From: Brenda Larsen
Sent: Wednesday, January 30, 2013 9:39 AM
To: Jeff Watson
Subject: RE: BL-12-00035 City of Cle Elum

Re: City of Cle Elum (BL-12-00035)

After conducting a review of the above named project, I have the following comments:

**BOUNDARY LINE ADJUSTMENT**  
 PREPARED FOR  
 CITY OF CLE ELUM  
 A PORTION OF SECTION 4,  
 TOWNSHIP 19 NORTH, RANGE 15 EAST, W.M.

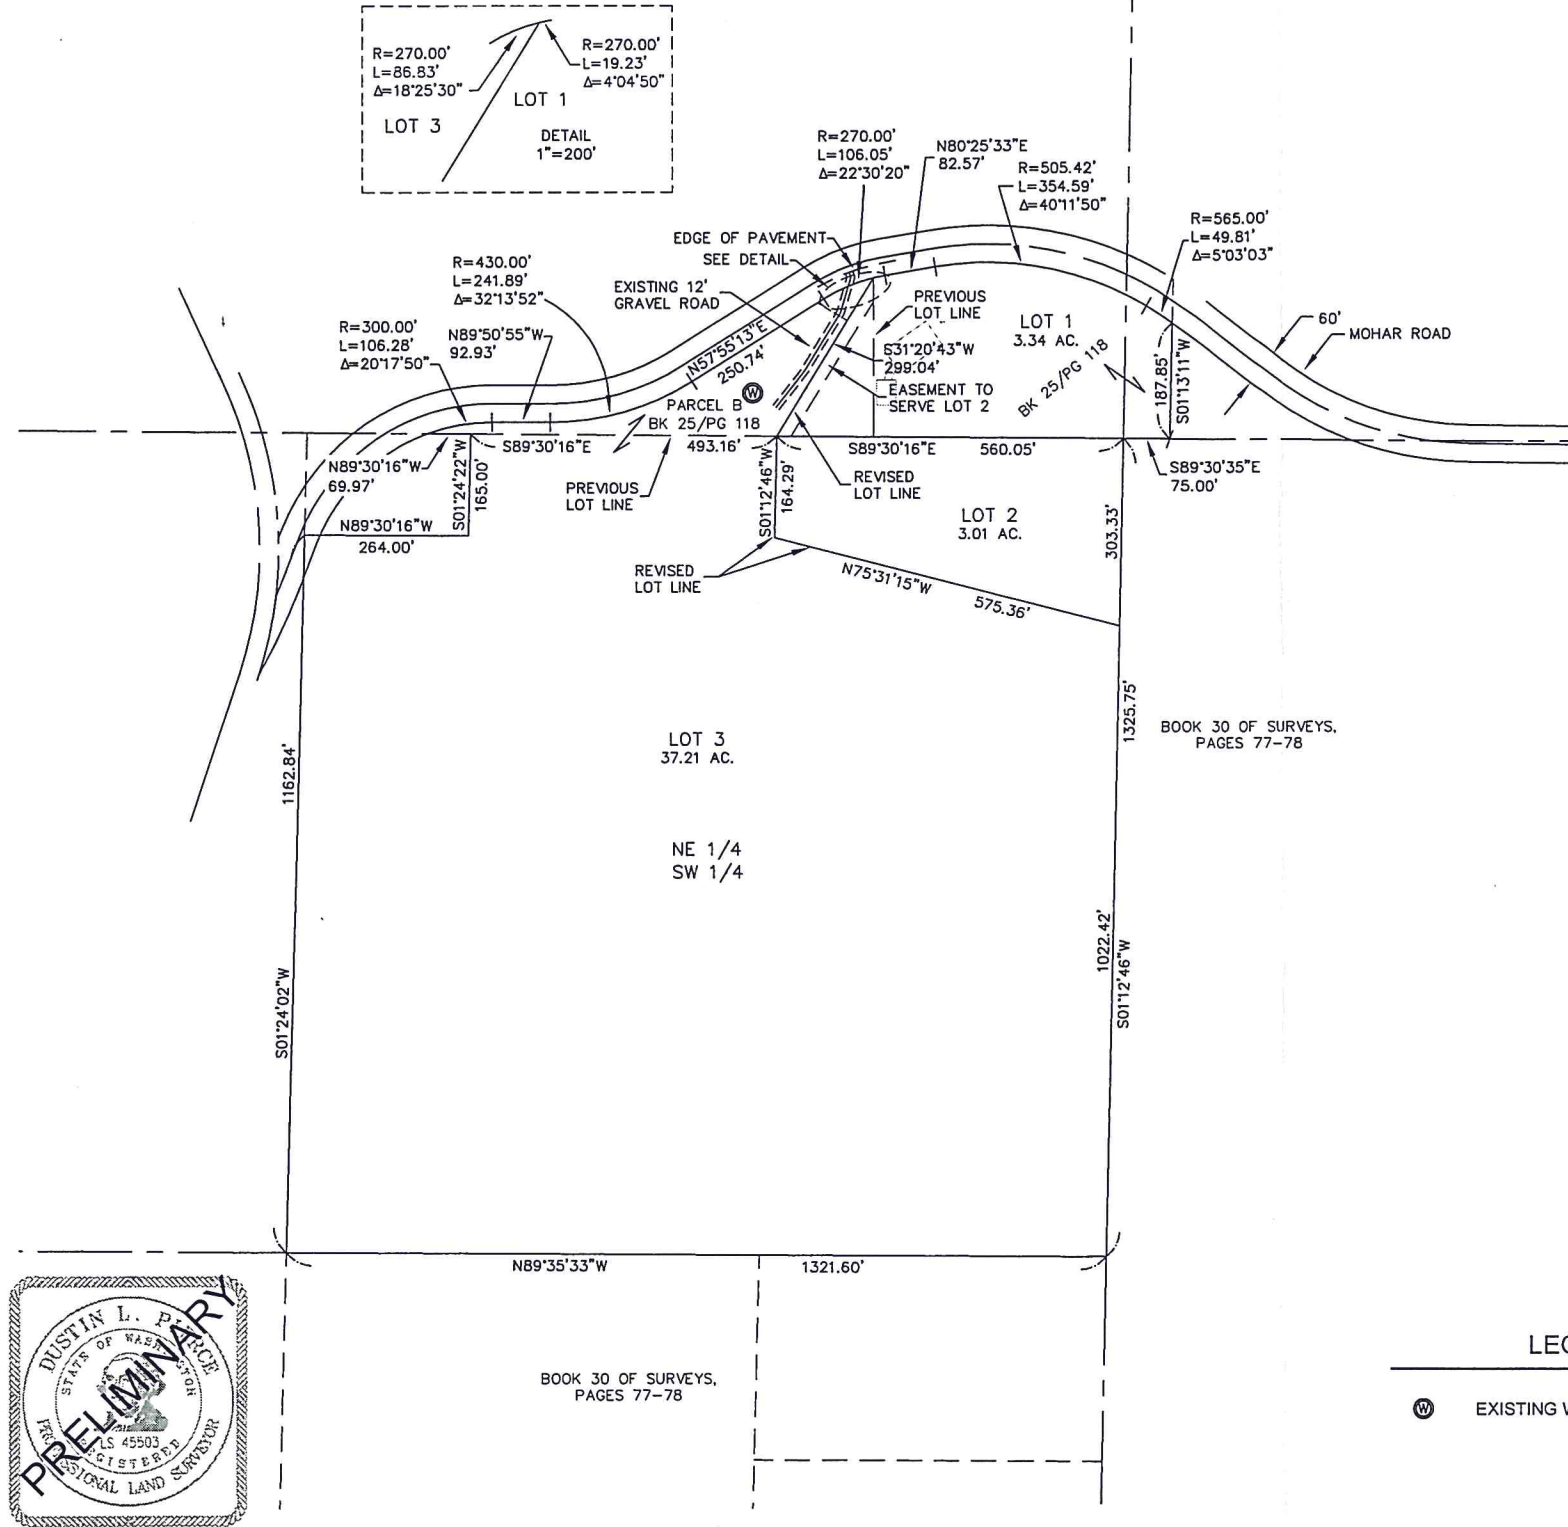
- Any new roads that are created are to comply with Kittitas County Road Standards and the International Fire Code.
- Ensure that boundary line adjustments do not infringe upon existing structures, to include propane tanks, etc.
- All future development must comply with the International Fire Code.
